## Appeal Decision

**Appeal Ref: APP/R5510/W/24/3357815**

**43 Rochester Road, Northwood, Hillingdon HA6 1NJ**

drw no: 644 / P3 / 1

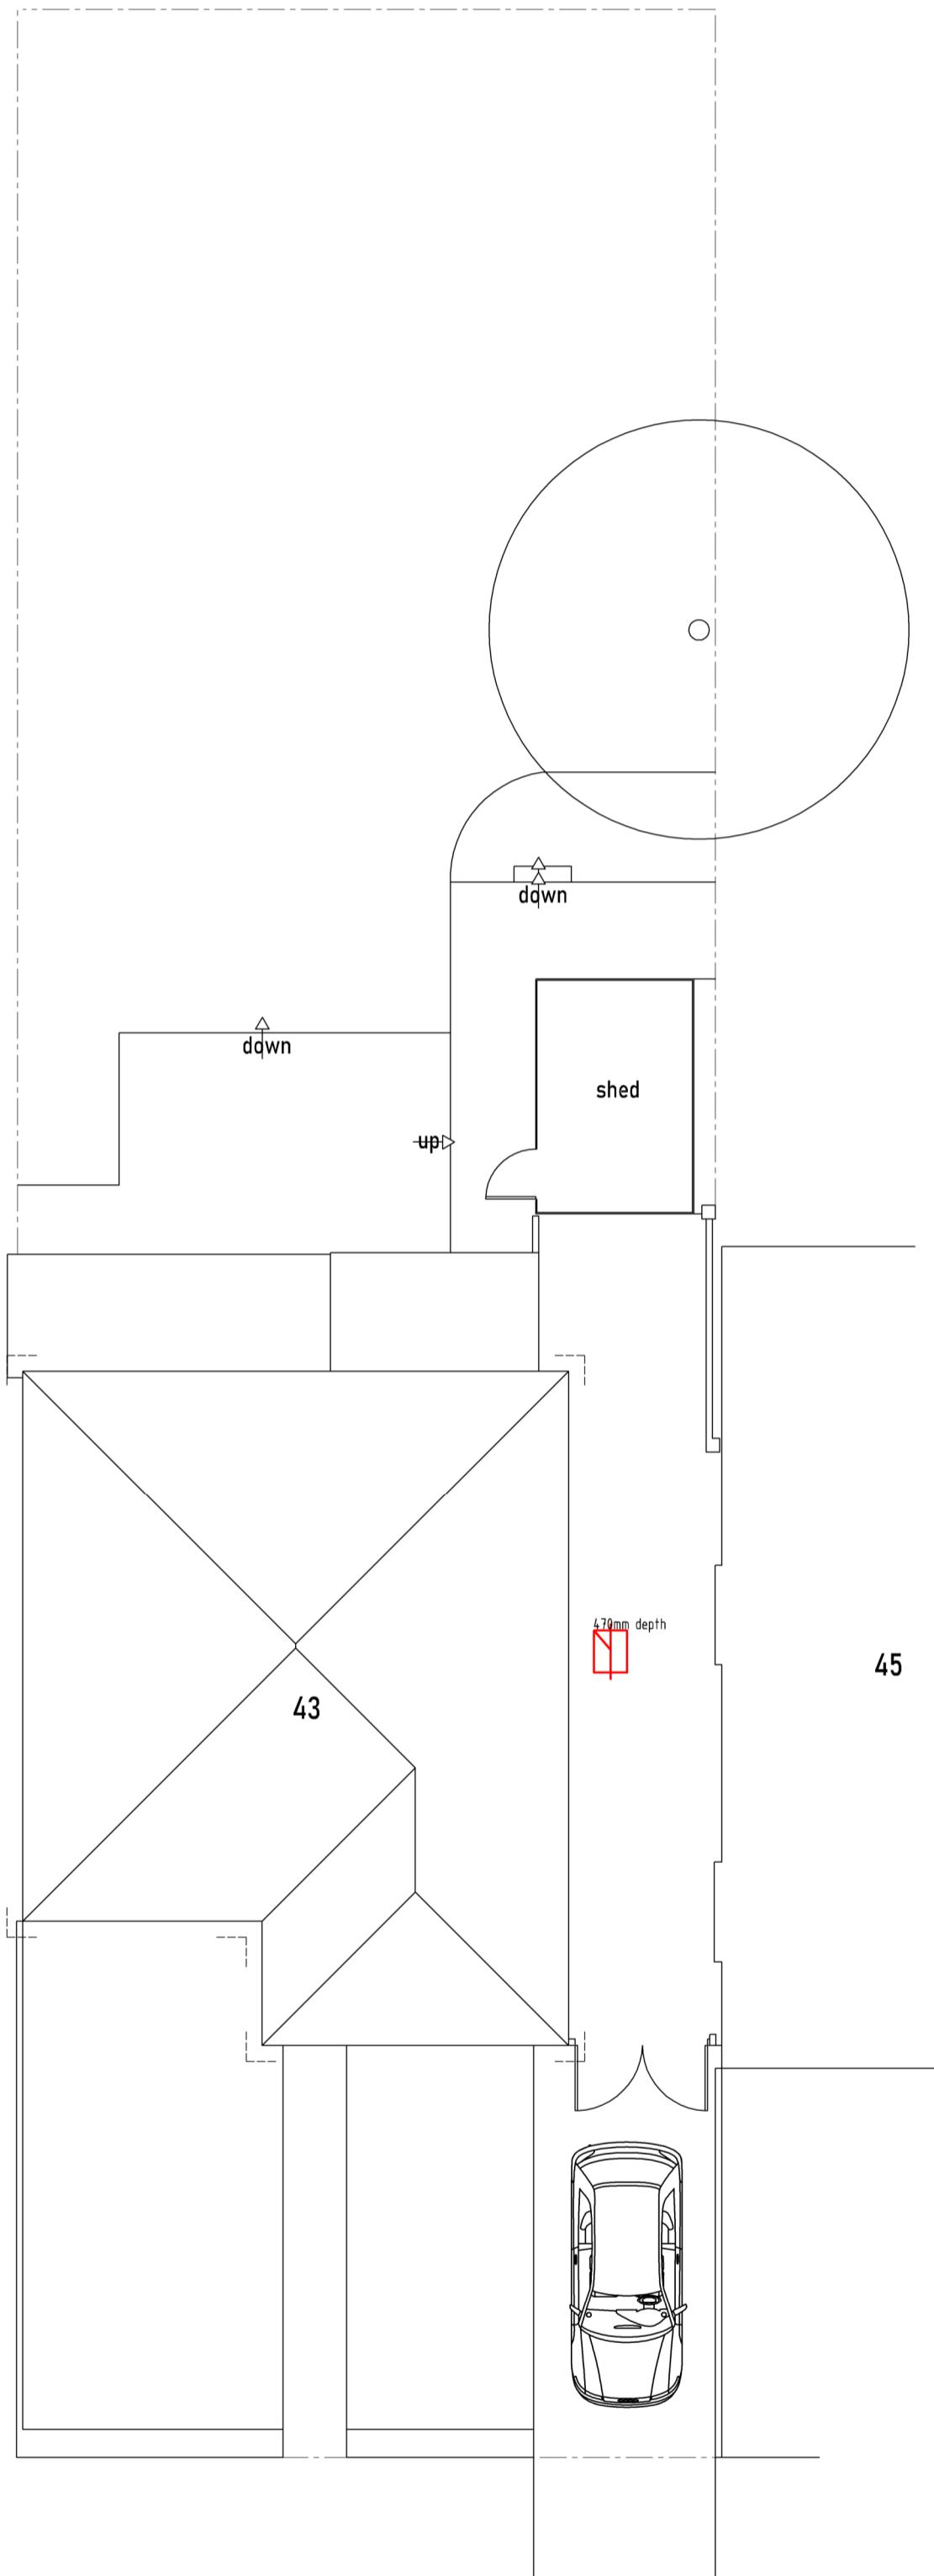
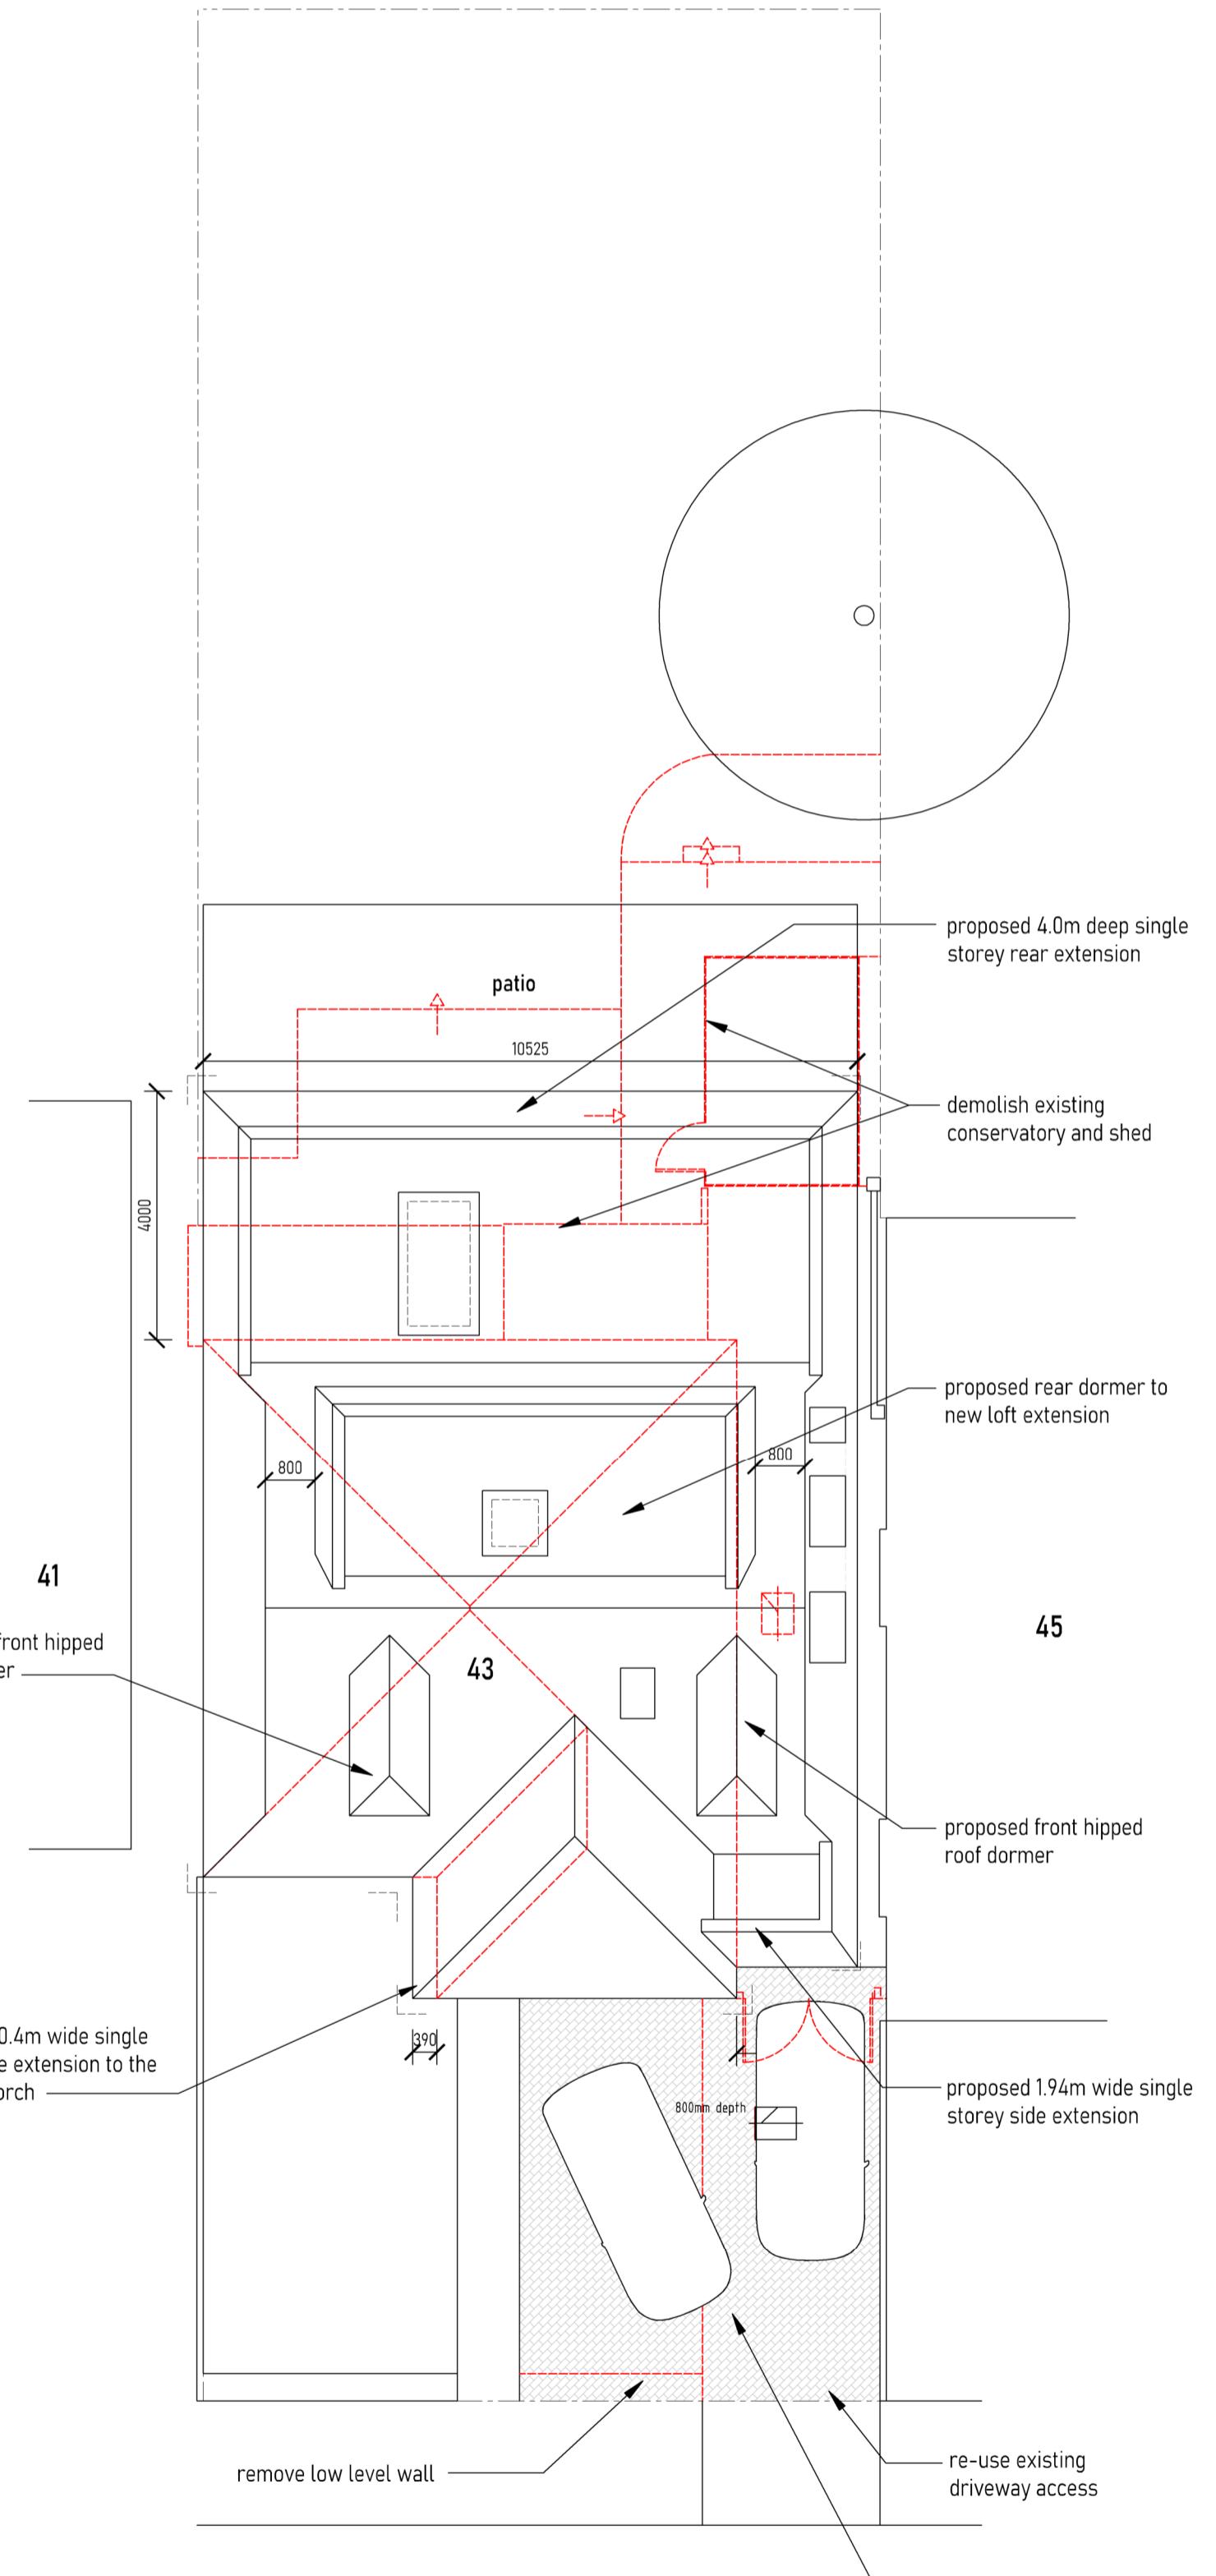
2. The appeal was accompanied by an amended Existing and Proposed Site Layout Plan, Drawing No 644/P3/1, showing no front dormer windows. The appellant has confirmed that front dormers were shown in error on the original drawing, and that front dormers were not part of the description of development and were not shown on the Proposed Floor Plans and Elevations. As such, no interested parties have been prejudiced by the correction of the error, and I have therefore determined the appeal on the basis of the revised site layout plan.
